# **OXFORDSHIRE COUNTY COUNCIL'S RESPONSE TO CONSULTATION ON THE FOLLOWING DEVELOPMENT PROPOSAL**

**Application no:** 14/01835/REM-3

**Proposal:** Reserved Matters to 05/01337/OUT - Details of the proposed village square including 44 public parking spaces and landscaped public open space

## Transport

Title  
 Planning Application 3:  
 Village Square

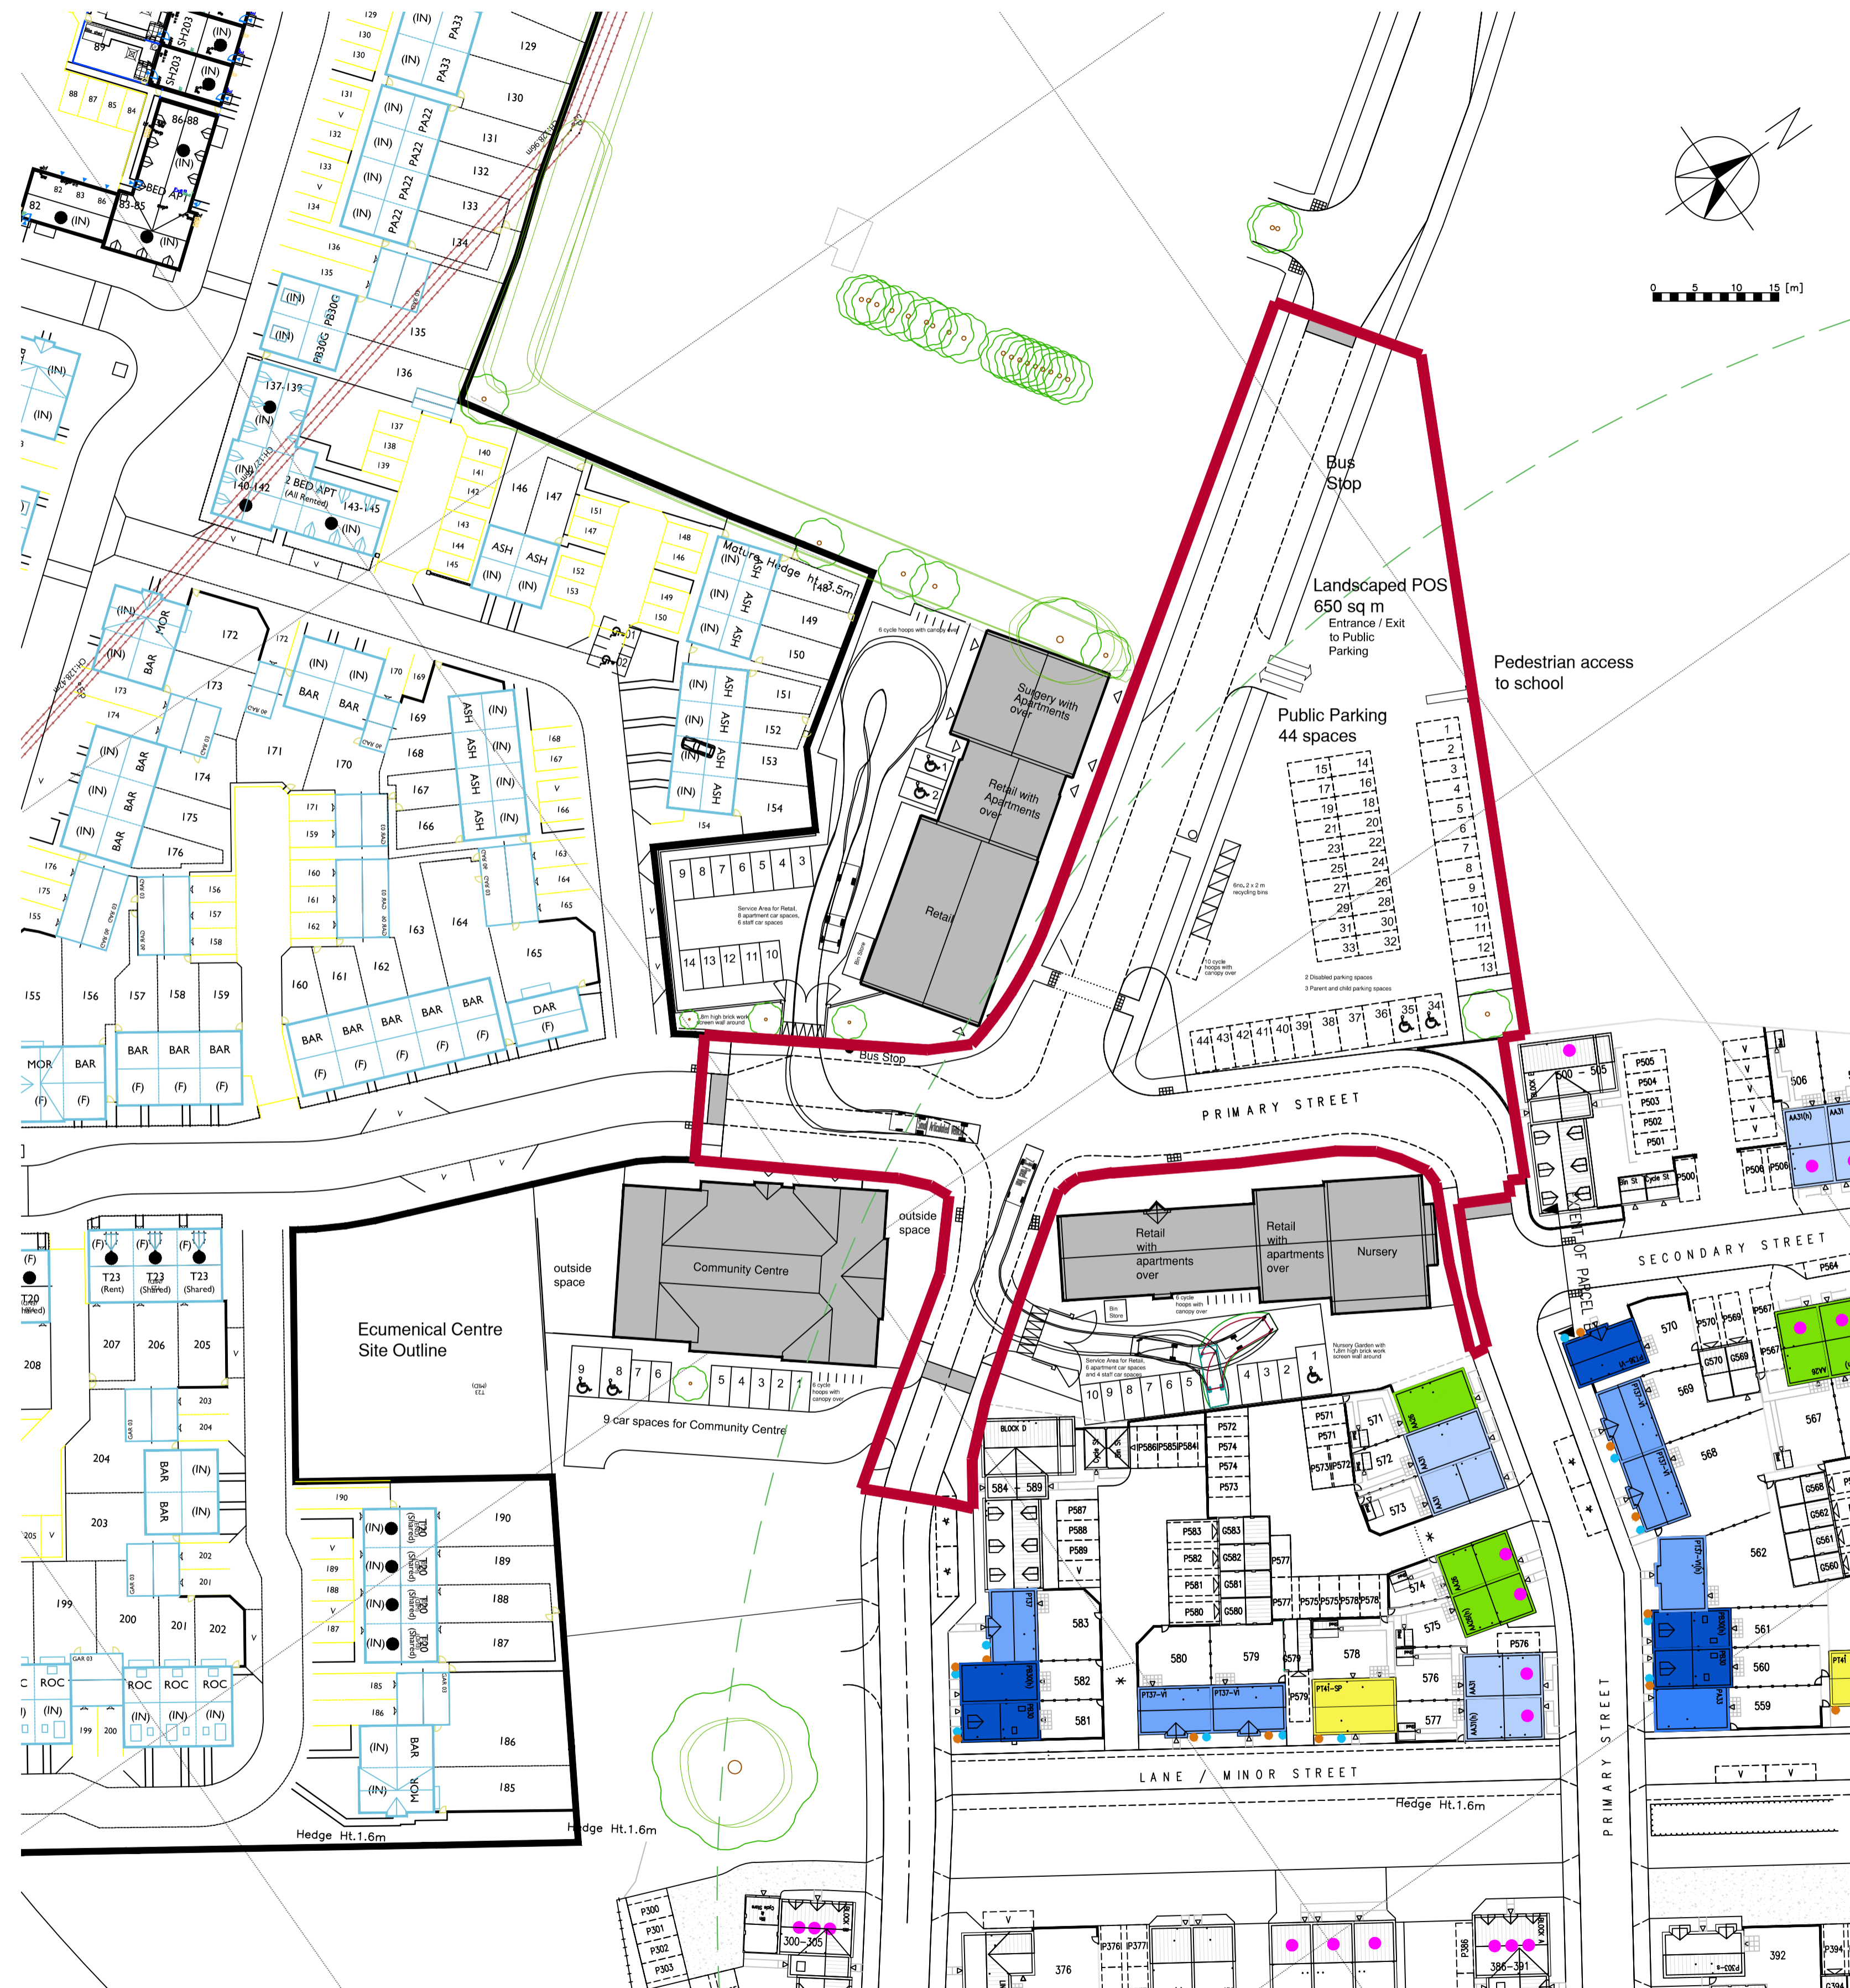
- Some points raised in previous response not addressed
- Tracking needs to be provided for the car park access – including for recycling vehicles
- Space allocated for cycle parking is insufficient

- 10 sheffield stands (with appropriate spacing) were requested to be provided. The space indicated for them is not adequate, being roughly the space of one car parking space, considering the stands should be 1 metre apart and the space is not wide enough for two rows of stands, including the cycles parked at them. There needs to be enough space around each stand to conveniently park cycles without damage, or people will be discouraged from using the cycle parking. As this is short term cycle parking, I would be happy for it not to be covered, if that helps the design. The important thing is to have sufficient space to accommodate different types of bicycle including those with wider handlebars, paniers, baskets and child carriers. The low levels of parking at the local centre mean it is extremely important to encourage people to walk or cycle there rather than to drive – that includes people bringing children to school – parents' bikes are unlikely to be allowed on school premises. Given my concerns that insufficient space is

being allocated to cycle parking, I would like to see a plan showing how the individual stands are laid out.

- The red line area includes parts of the spine road which was the subject of a separate reserved matters application. The outline of the road in this application does not match up with the spine road plans, in particular the service layby at the front of the convenience store is not shown (although the bus layby around the corner has now been shown). This is required because the layout of the yard behind the store is too tight to allow for the larger lorries that may deliver to the convenience store.
- The car park now has one entry/exit point. Tracking is required to show that cars entering and leaving the car park can pass one another at this access, to avoid cars having to wait on the spine road, causing congestion on the bus route. As recycling bins have been introduced, this must also allow for the larger glass collection vehicles that will need to enter the car park.
